Office of Water

1 September 2010

Proposed Development Activity - 89 George Street, Parramatta, Application NCA/3/2010

01 PLAN - BASEMENT 3
SCALE 1:200 20 CARS

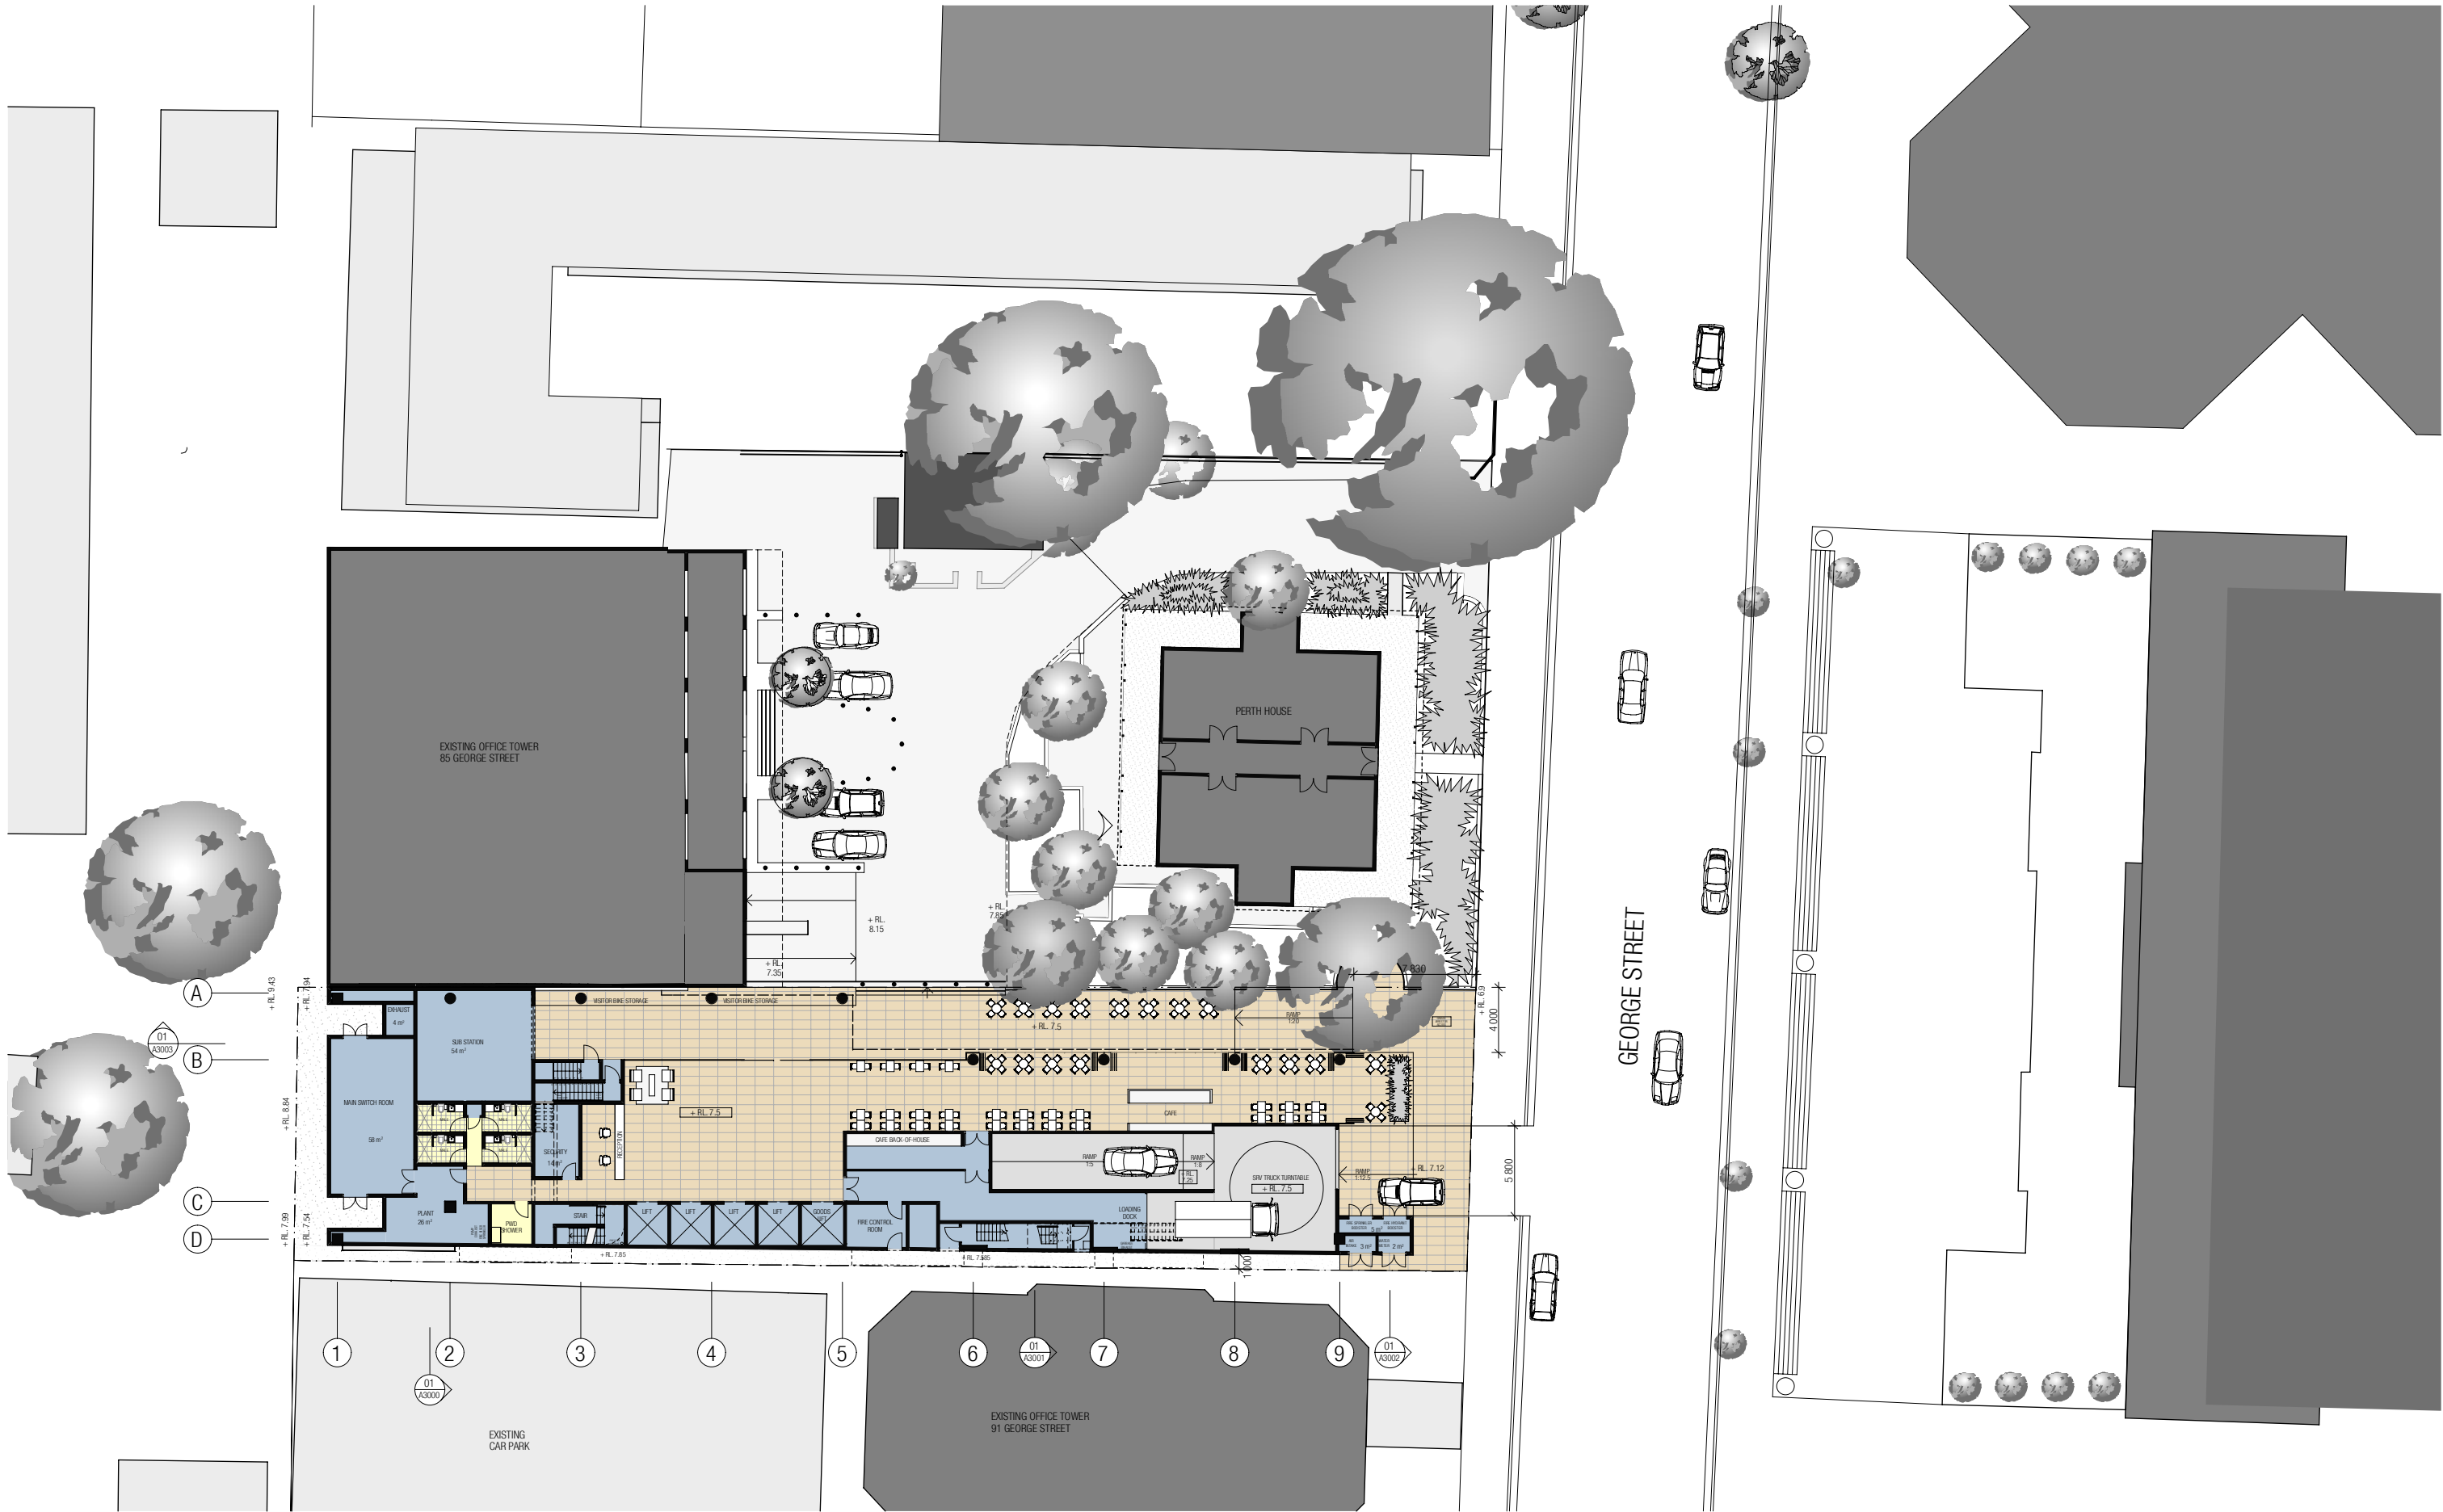
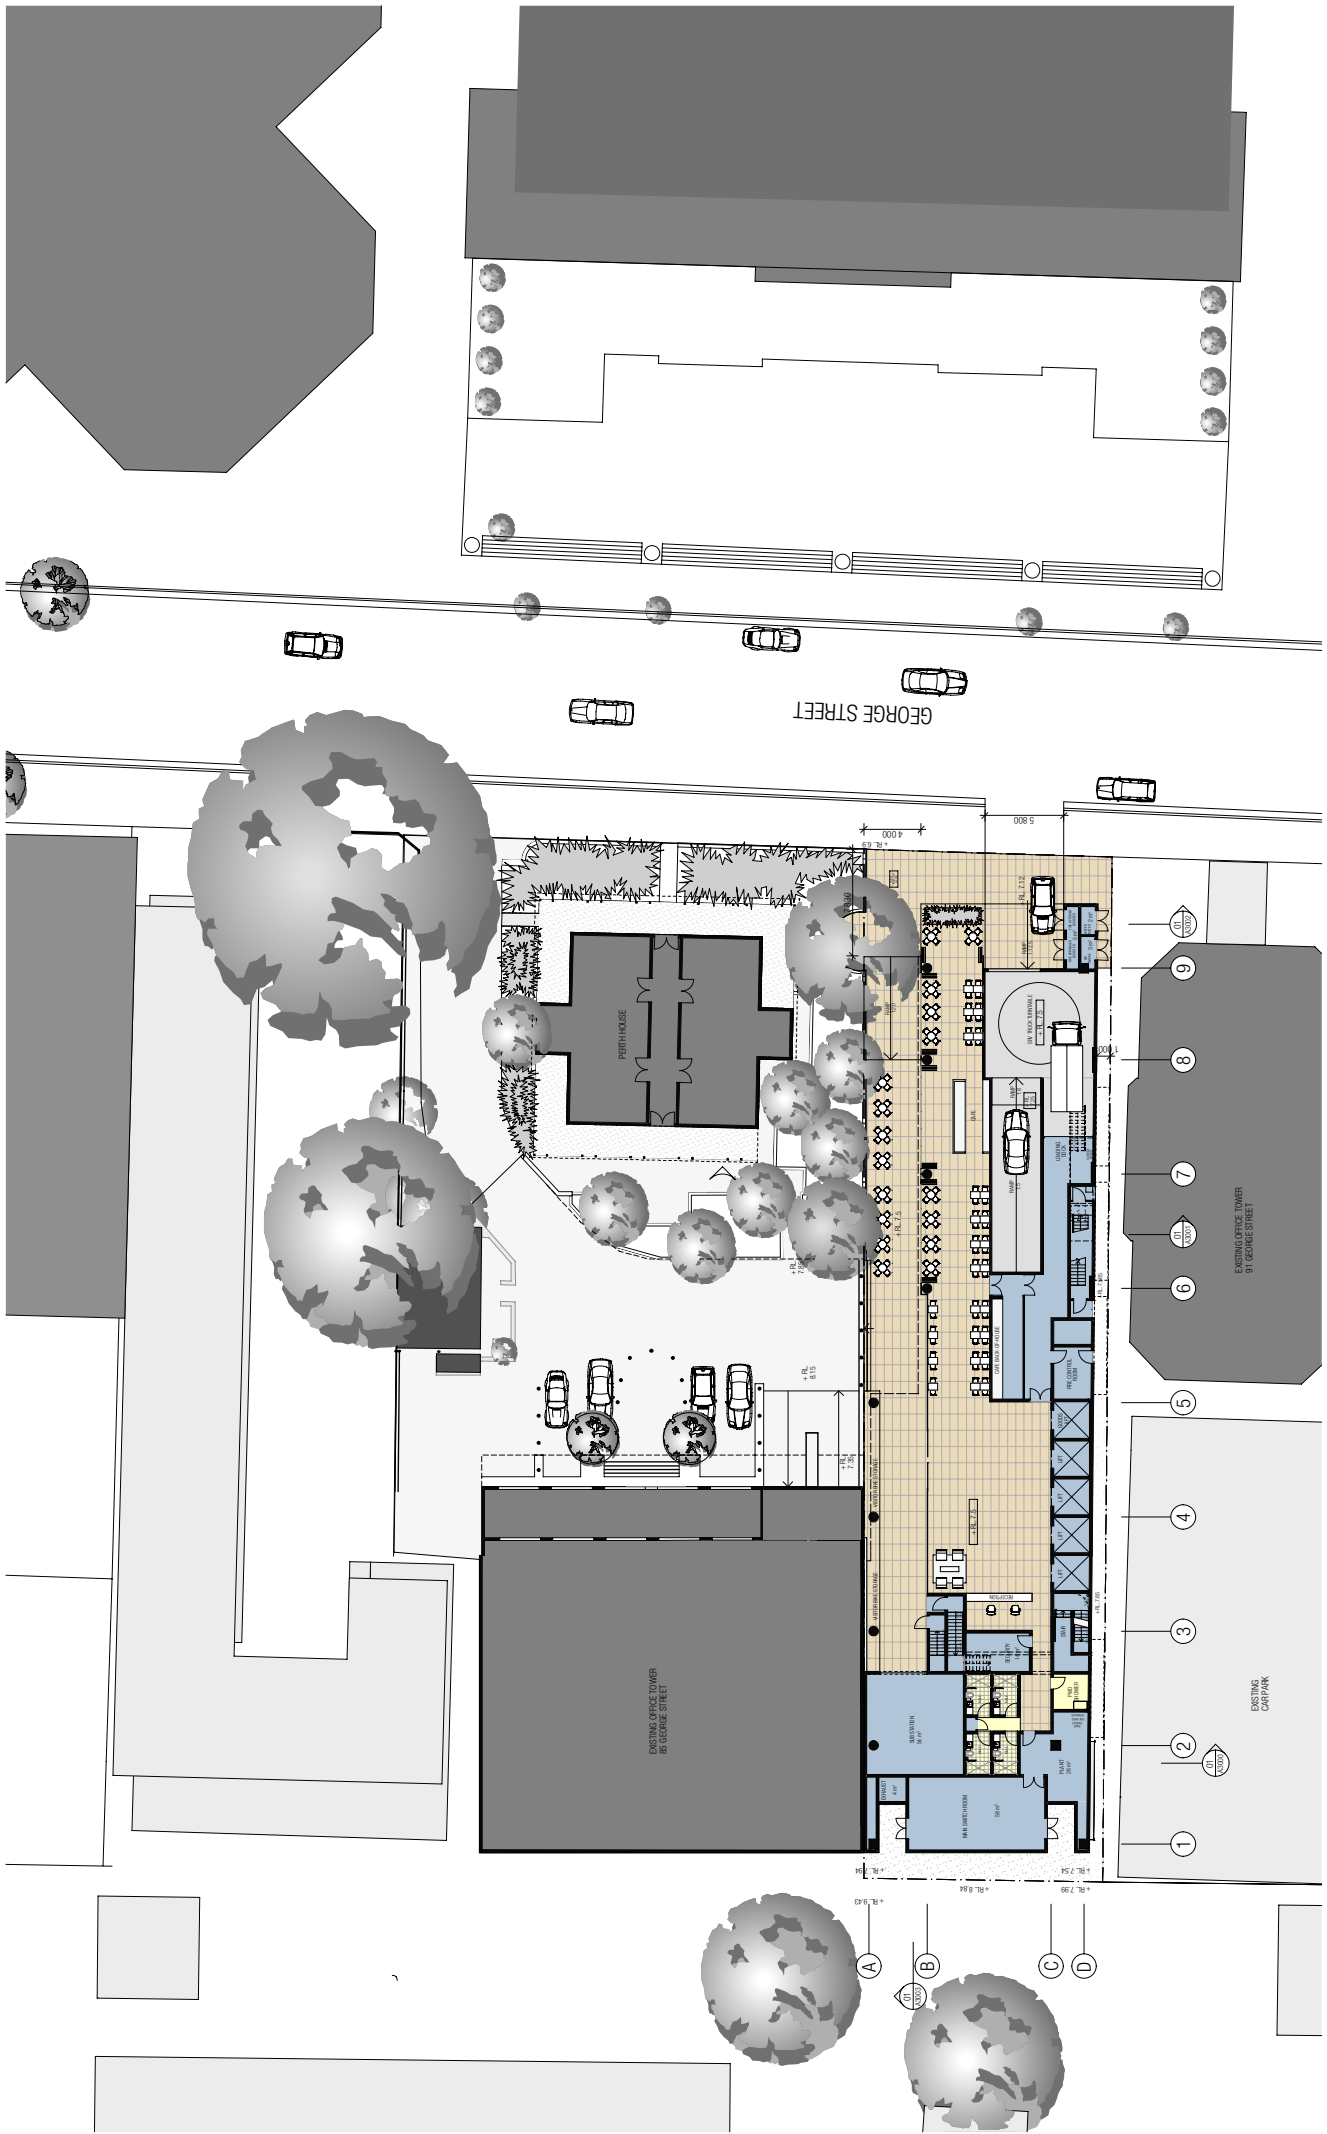
- The site sketch by Douglas Partners indicates the presence of shallow groundwater.
- The design sketch of below-ground voids by Enstruct includes provision for tanked basement construction.
- The contamination and acid sulphate soils assessments reported by SMEC Testing Services indicate the potential for adverse impacts from the development.

Given these considerations, it is recommended that the basement areas be built as 'tanked' (i.e. waterproof) constructions to prevent future adverse impacts on occupants and the surrounding environment as a result of (potentially aggressive or contaminated) groundwater reporting to the below-ground voids. Council may also wish to apply a requirement for the
